Cassio Engineering, Inc.

April 26, 2016

**Re: Anchor Bolt Attachment to Base Rail
Standard Carports**

CONCRETE BASE RAIL ANCHORAGE

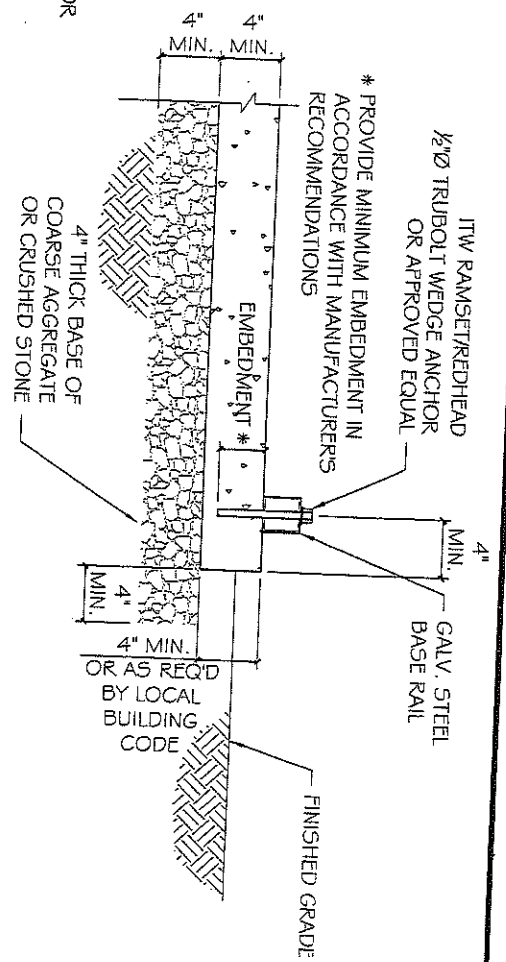
The standard plans show several options for attaching the base rail to the concrete slab with ½" anchor bolts. The most important parameters for installing the anchors bolts are the 4" minimum distance to the edge of the slab and the minimum embedment of 2¾" into the concrete slab. It is acceptable to weld a short piece of steel tubing to the inside face of the base rail and attach the anchor bolt with that in order to obtain the minimum 4" clearance to the edge of the slab.
